COUNTY COUNCIL'S RESPONSE TO CONSULTATION ON THE FOLLOWING DEVELOPMENT PROPOSAL

Application No: 21/00503/F

Proposal: Use of the site for the storage of operational vehicles, elevational alterations, associated parking, vehicle barriers, guard hut and associated infrastructure

Location: Banbury 200 Southam Road Banbury

**PROPOSED SITE PLAN**  
1:500

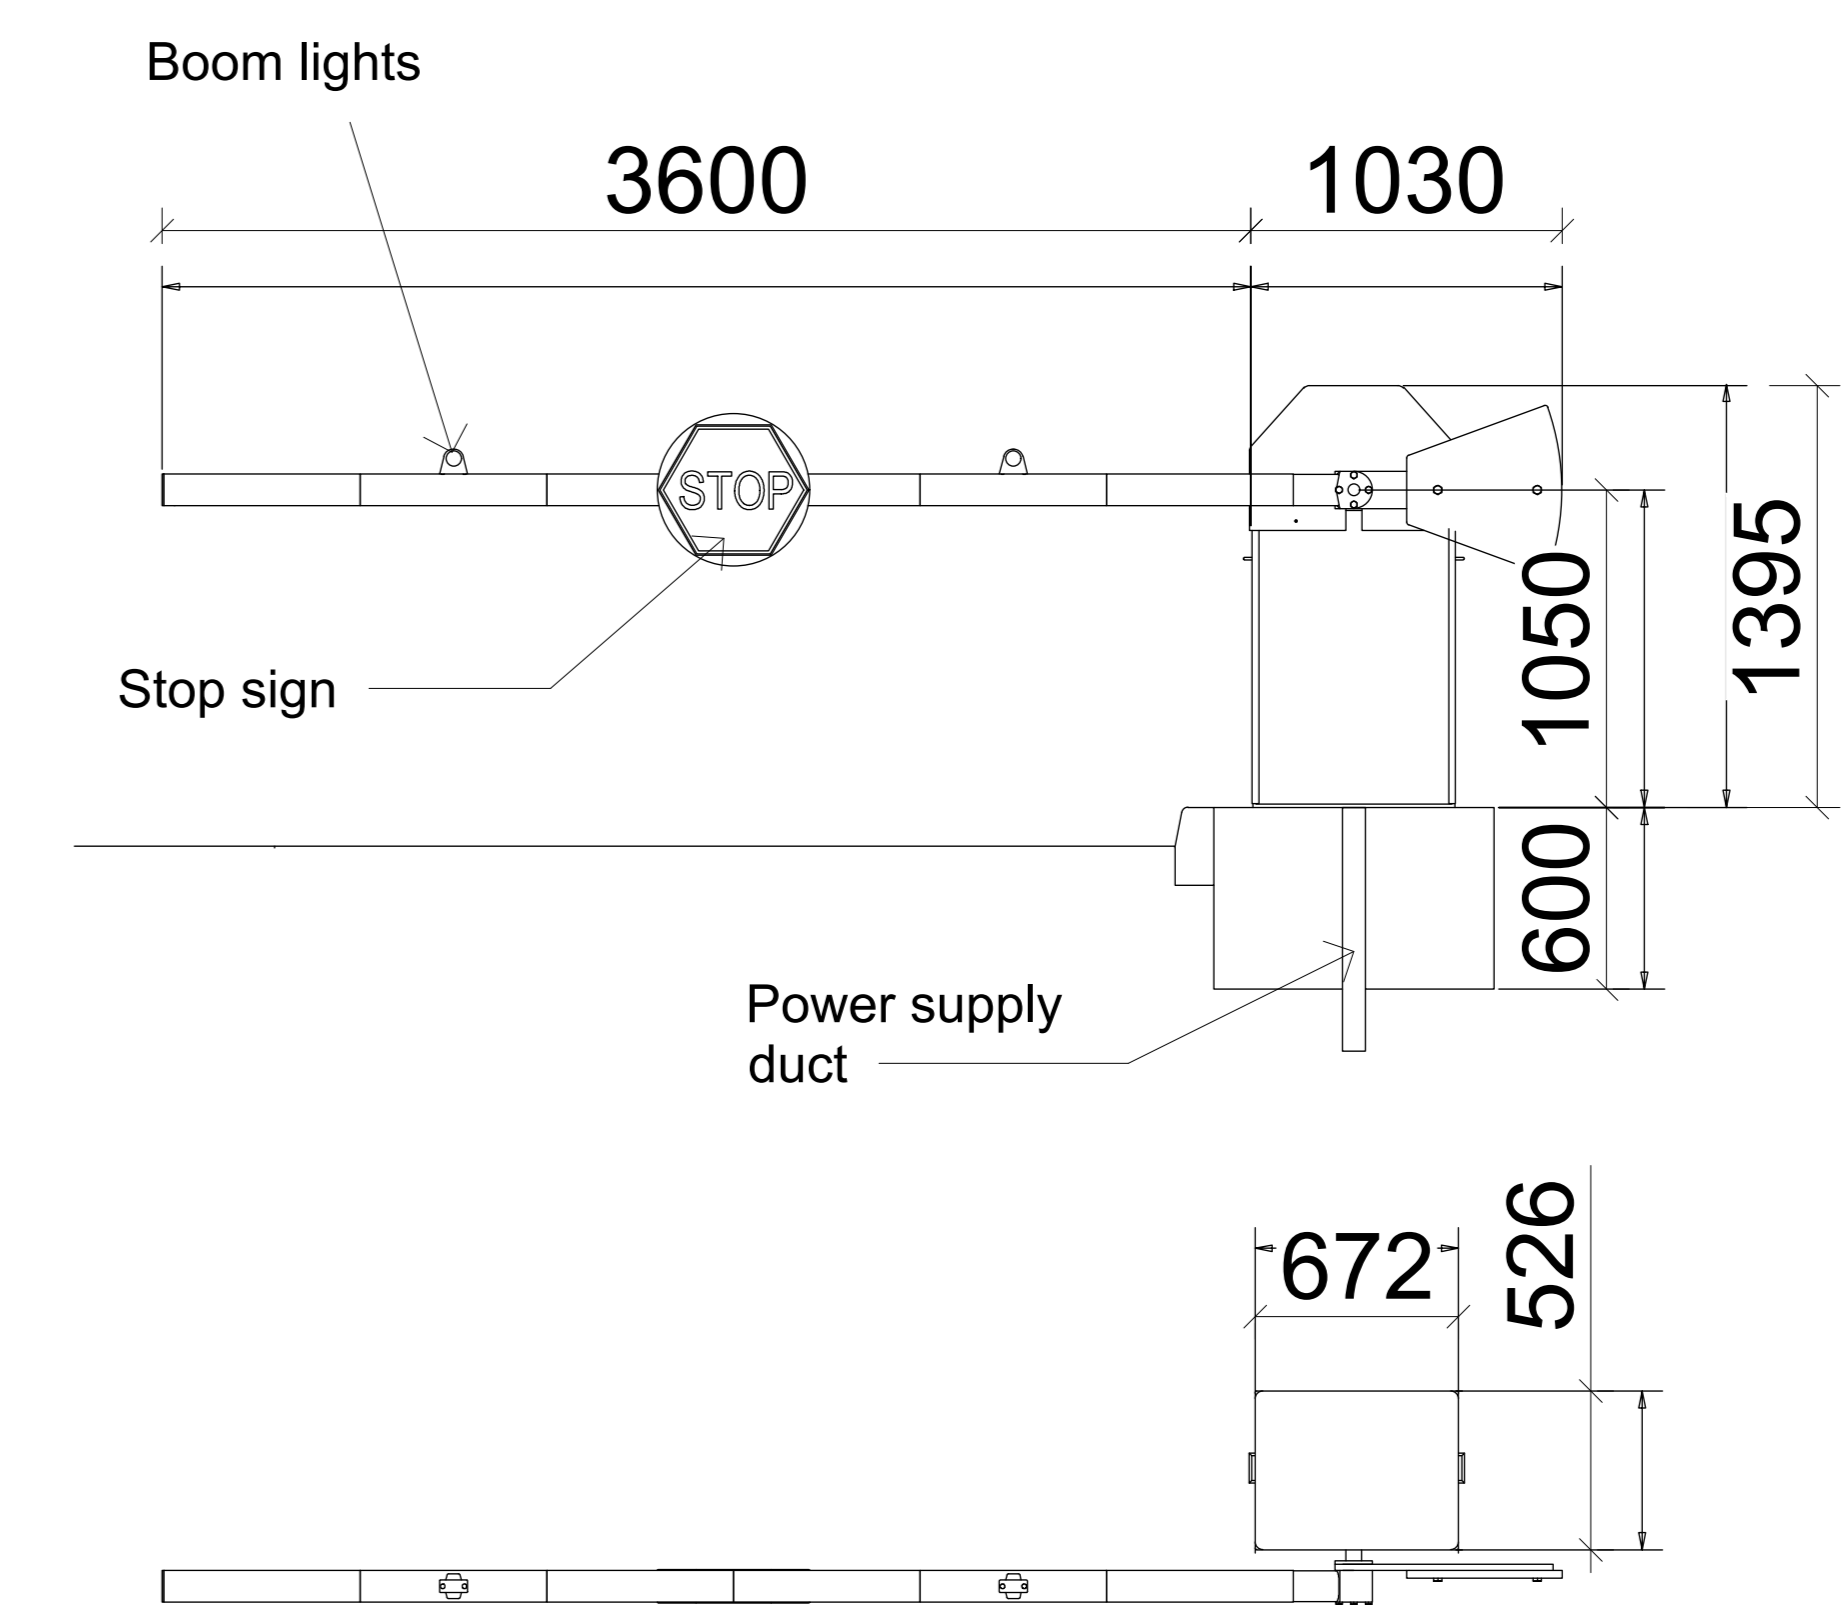
Access to the site will be achieved from the existing priority junction onto Southam Road which is shared with a neighbouring Waitrose Service vehicle entrance and an emergency exit-only egress is proposed to the north-east of the site through an existing left turn only junction onto the A422

Regarding the access, the Applicant should ensure that the gradient and sightlines complies with current highway design Standards and has sufficient drainage and ensure the dimensions are appropriate for servicing the site.

- The need for the access arrangements to be accompanied by swept path analyses of the vehicles likely to access the Van storage site together with drawing showing compliance to highway Visibility Splay Standards.
- Southam Road is about 6.5m wide including an on-carriage cycle lane which further reduces the effective carriageway width. No provision on carriageway to the van park access has been made by Applicant to address the issue of the heavy turning flows into and out of the van storage site or mitigate the adverse impacts on 'through' traffic and cyclist in that area. The Applicant should

consider widening that section of the carriageway for a right turning pocket facility in order ease the movement of passing traffic.
